Planning Department Transportation Development Services

Re: Green Jeans Farmery Shell Permit

Certificate of Occupancy – Transportation Development Administrative Amendment dated 3-11-15 (H17-D036A2) Certification dated 10-20-15

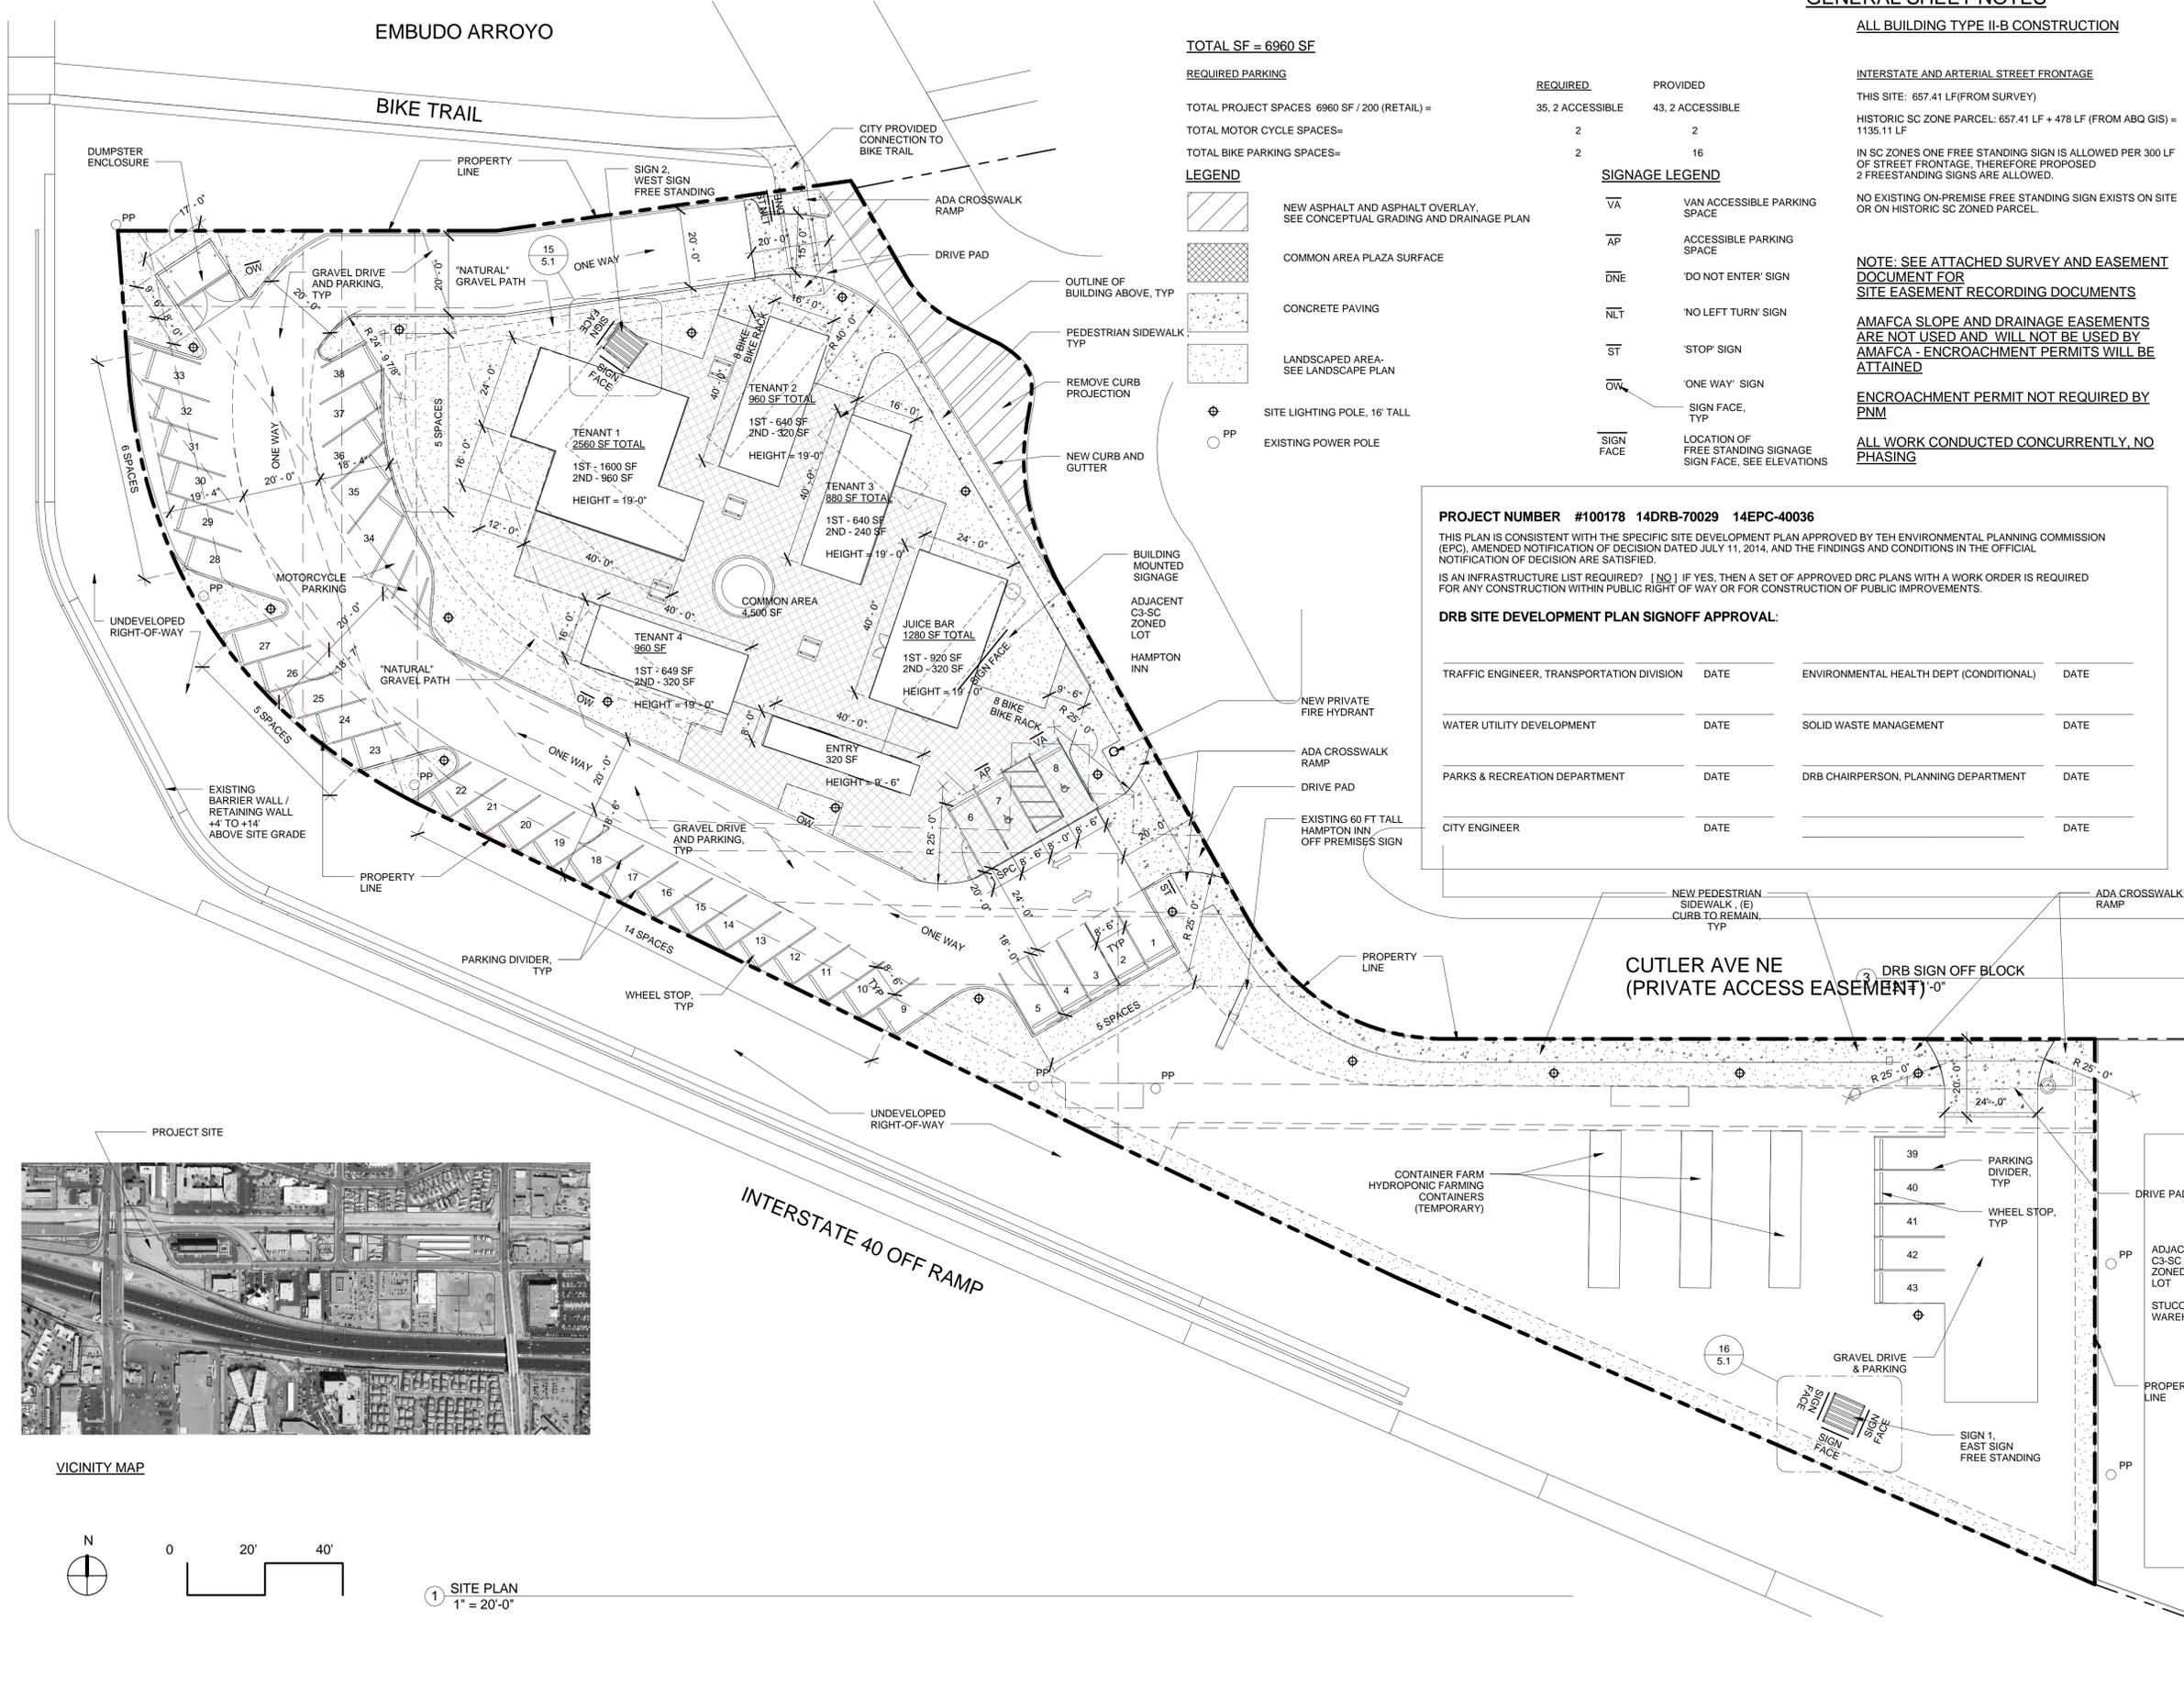
- 5. Show the water quality pond and associated channels and rip-rap on the Site Plan, Sheet 1.
- 6. Hydrology has also included an e-mail from AMAFCA concerning the necessary required permits that have not yet been obtained. The applicant should contact Lynn Mazur as soon as possible. The necessary permits should have been obtained prior to building permit approval, but instead will be required prior to Certificate of Occupancy.
